DPP Planning
Studio 015, Haylofts
St Thomas Street
Newcastle upon Tyne
NE1 4LE

Ref: KD/LF/ER/4066NE/L005

Date: 29th March 2023

Application for a Section 73 minor material amendment application in respect to conditions 2 (Approved Plans) and 5 (EV Charging Details) of planning application reference 21/03106/FUL to allow for minor external amendments, approval of EV charging point details and an amendment to the EV charging strategy of the approved Co-operative Food store at Mace Convenience Store, Townfoot, Rothbury, Morpeth, Northumberland, NE65 7SL.

**TITLE**  
EV Charging Point detail

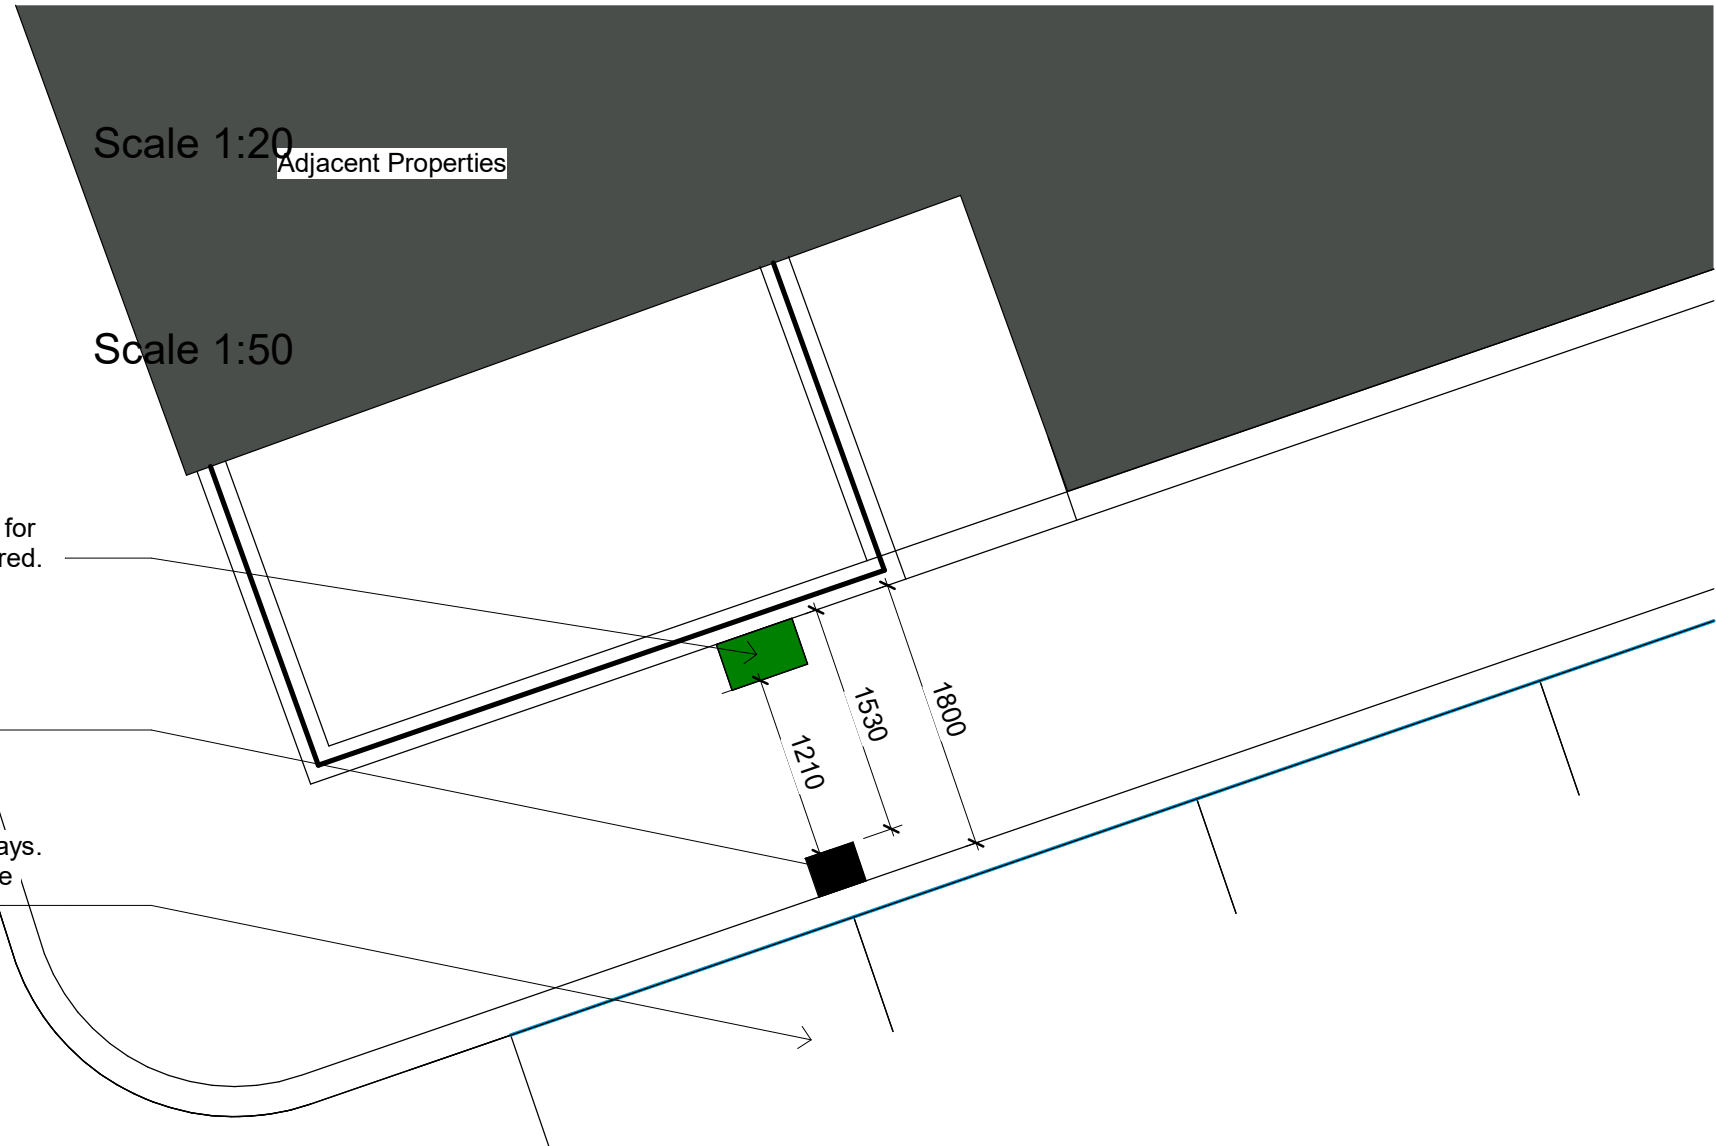
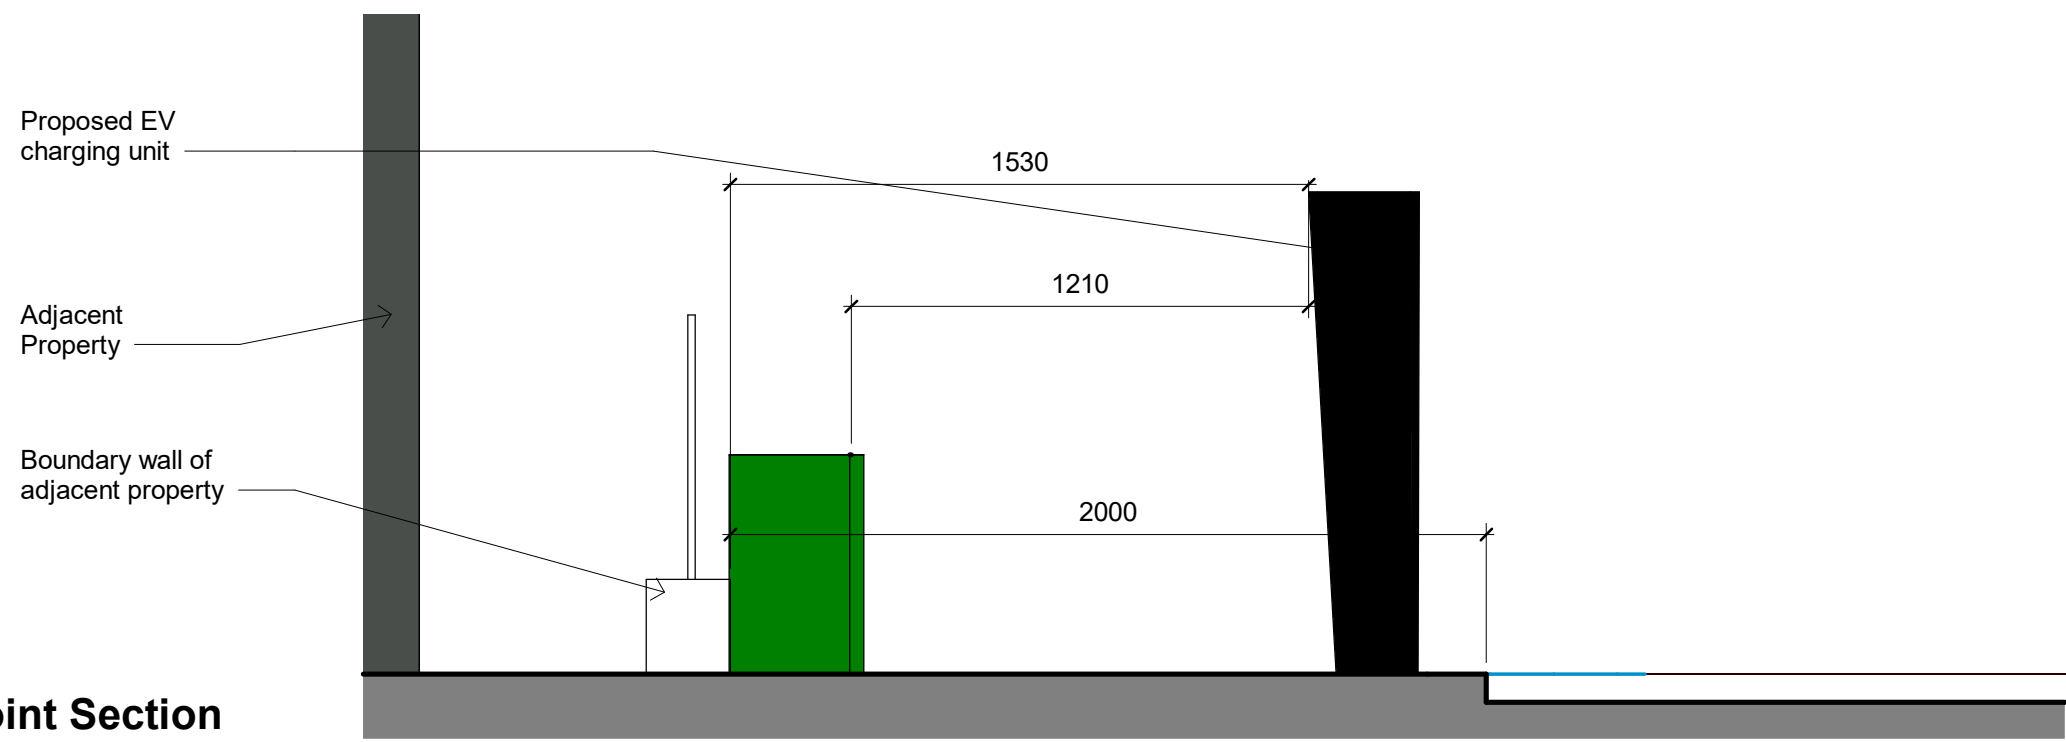
Although largely dealt with under condition 5 as referred to below, it is proposed to relocate the EV charging points originally proposed outside of the shop to the opposite side of Townfoot. The Proposed Site Plan and Highways Works Plan have been updated accordingly and we have submitted an additional EV Charging Point Detail Plan and supporting brochure for approval.

We have also submitted the EV charging point data sheet (ref: EVAD-V01-R6) which provides further details on the currently proposed EV charging points. Please note, the EV unit will be a single device which will have a dual charge specification to provide for two EV charging bays. The green box indicated on the Highways Works Plan unit is to allow Northumberland County Council to install an electric meter should this be required to administer the EV charging point.

“Within 12 months of occupation of the development, the approved electric vehicle charging point shown on the Highways Works Plan ref: 21016-GDL-A1-00-DR-A-2106 rev C05, the EV Charging Point Detail plan ref: 21016-GDL-A1-XX-DR-A-2495-D3-P01 and the ROLECEV Autocharge Data Sheet (or other similar alternative agreed with the LPA); shall be installed. The electric vehicle charging point shall thereafter be retained in accordance with the approved details and kept available for the parking of electric vehicles at all times.

TITLE  
**GA Elevations North & East**

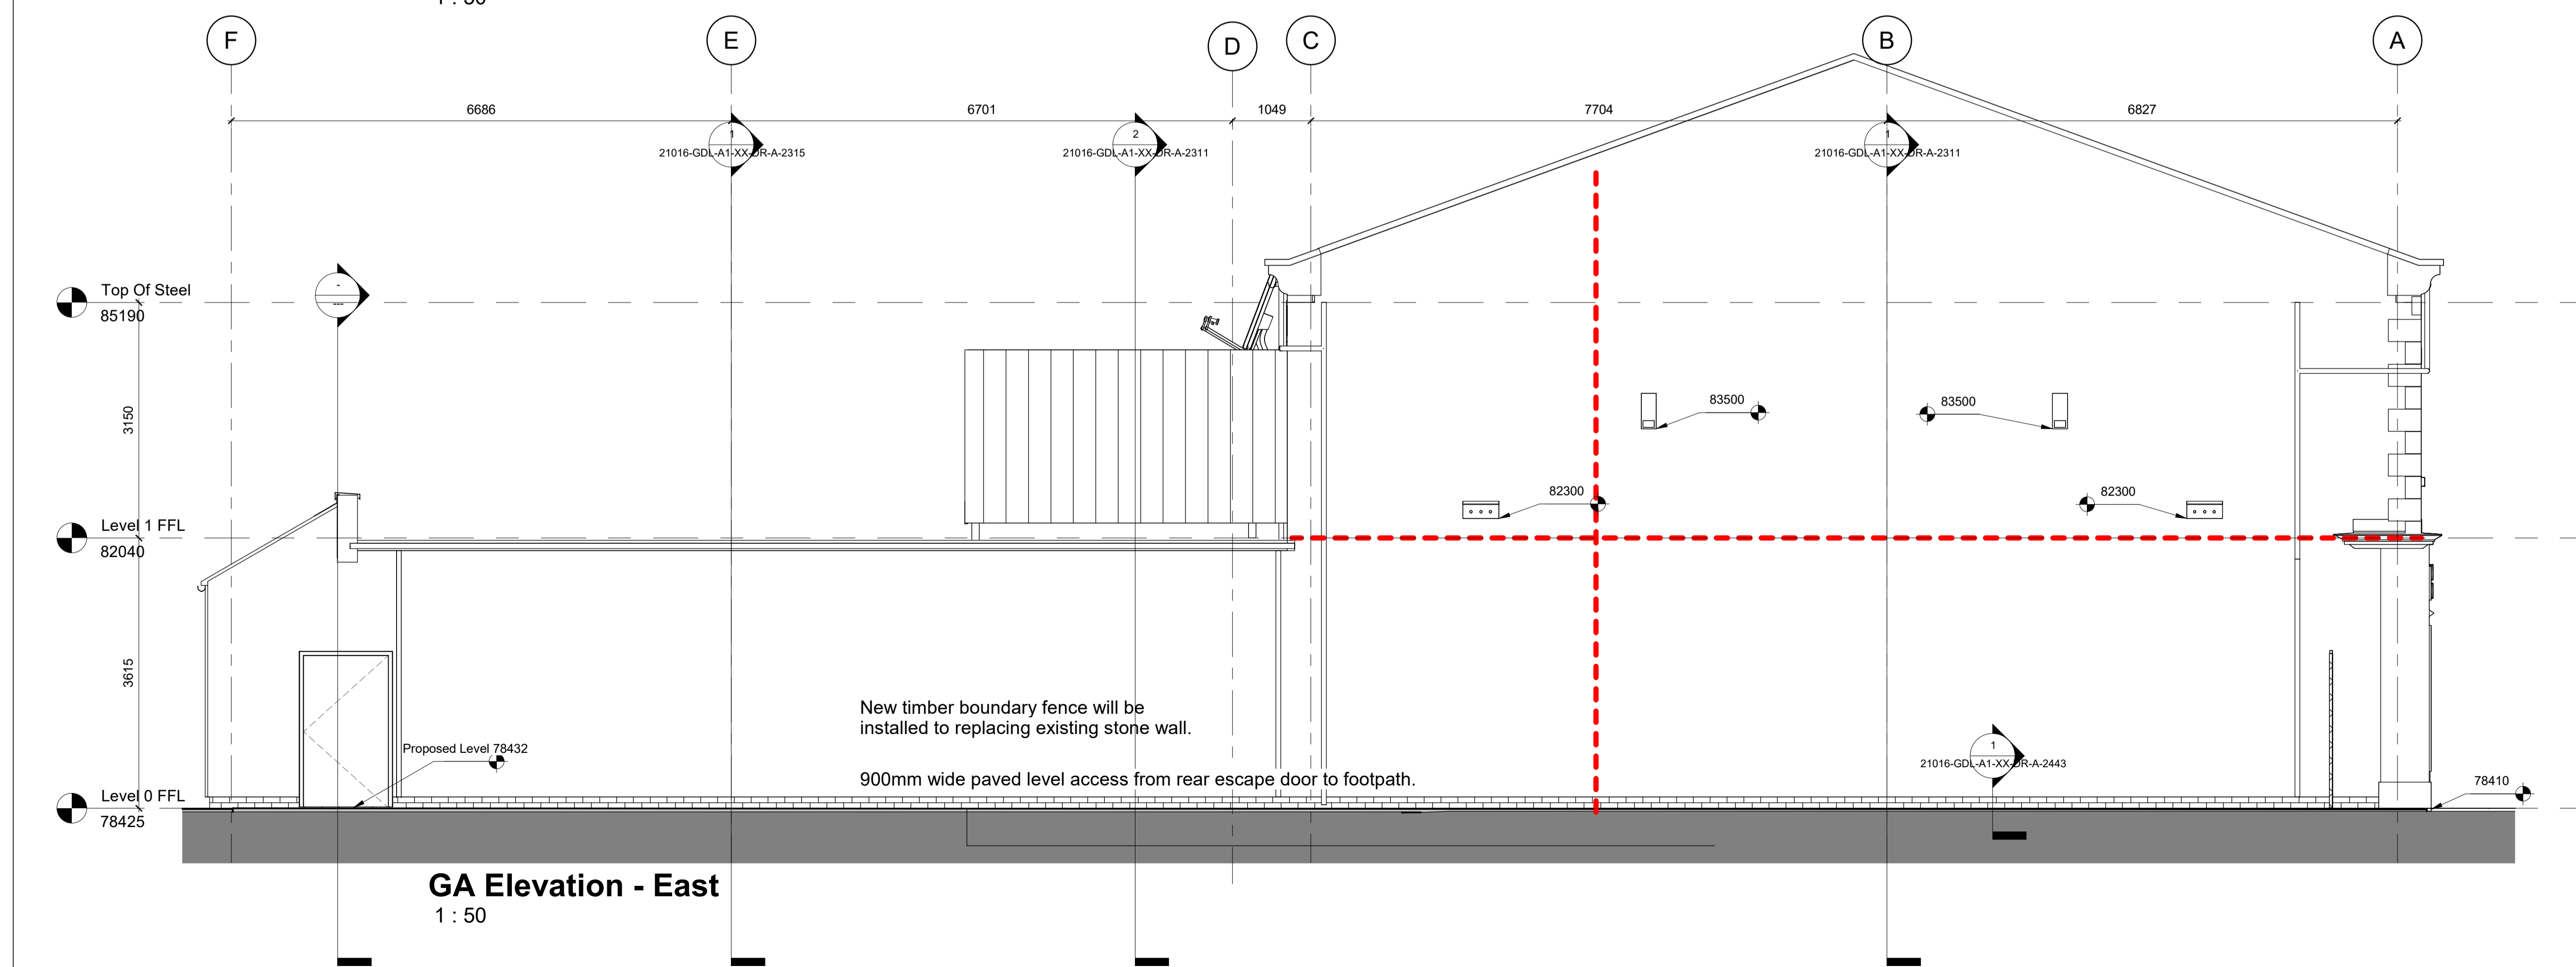
The updated Level 0 GA Plan, North & East Elevations and Shop Front Detail Elevation also account for new bollards which are required to protect the ATM machine. The submitted bollards details sheet (ref: 11S019-S01-ISSUE-08) provides further information on the specification of the bollards.

TITLE  
**GA Elevations South & West**

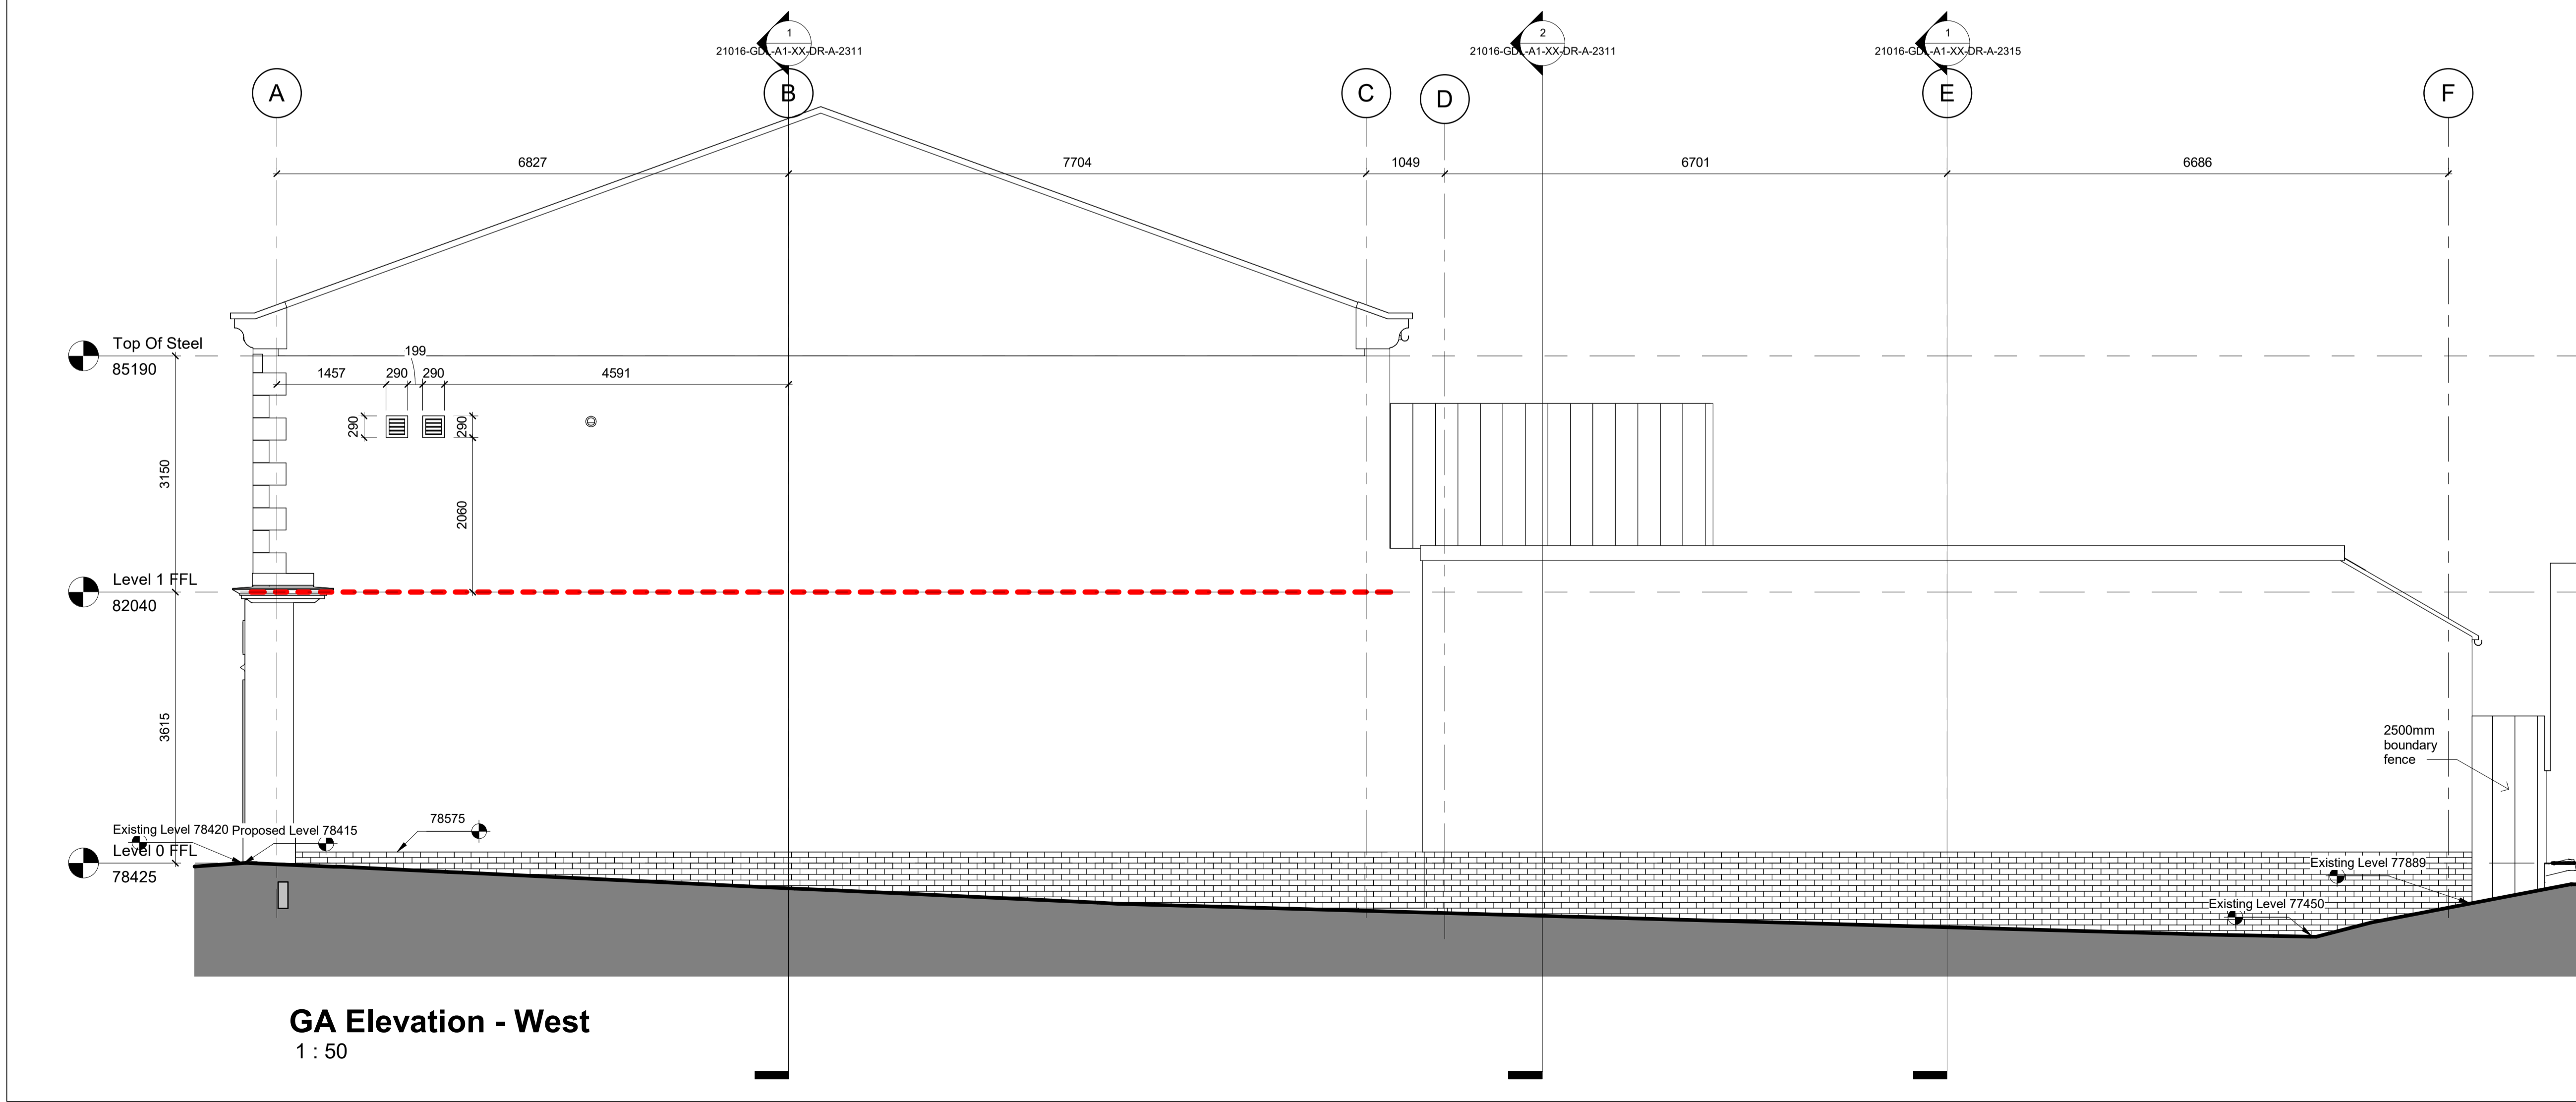
In addition to the above, the first floor, rear quoin detailing approved on the proposed elevations plan is to be removed as the rear elevation has limited visibility and due to the fact that it is proposed to be largely screened by the timber fence.
